**ADC Planning Consultation
Response from the Conservation Officer**

Application Number	FP/185/13/
Address	75 Felpham Road Felpham PO22 7PB
Description	Change 2 No front windows to make longer.
Case Officer	Mrs. J Chapman

Windows

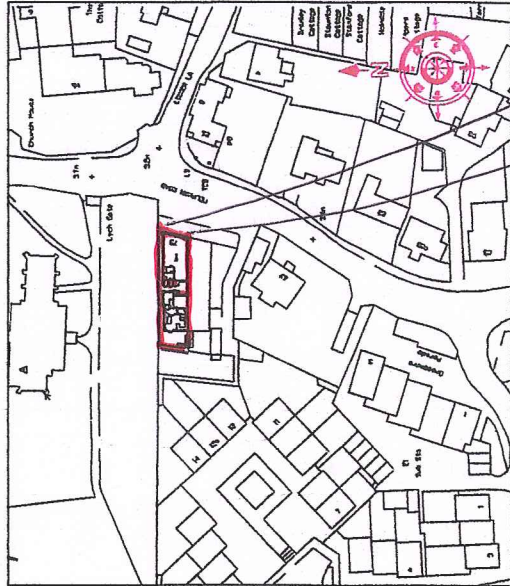
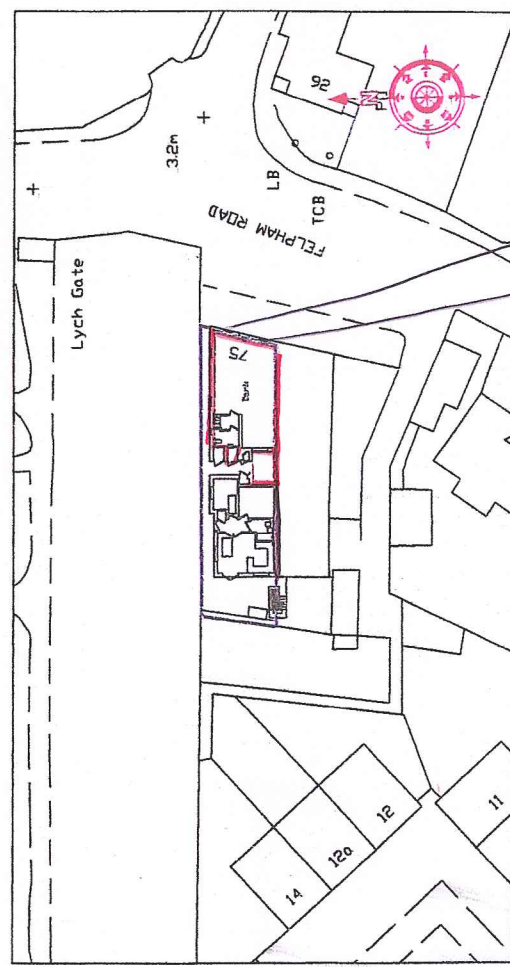
The proposal as it currently stands involves lowering the windows. It is considered that this will, on its own, not have an un-due detrimental impact on the conservation area of the property. However, this is subject to the windows closely reflecting the appearance of the existing ones.

Based on the information provided as part of the application, is not clear how the windows will look and I suggest that this can be dealt with by condition.

Further, all materials such as the existing original bricks etc. should be reused as part of the scheme.

Materials and details of windows
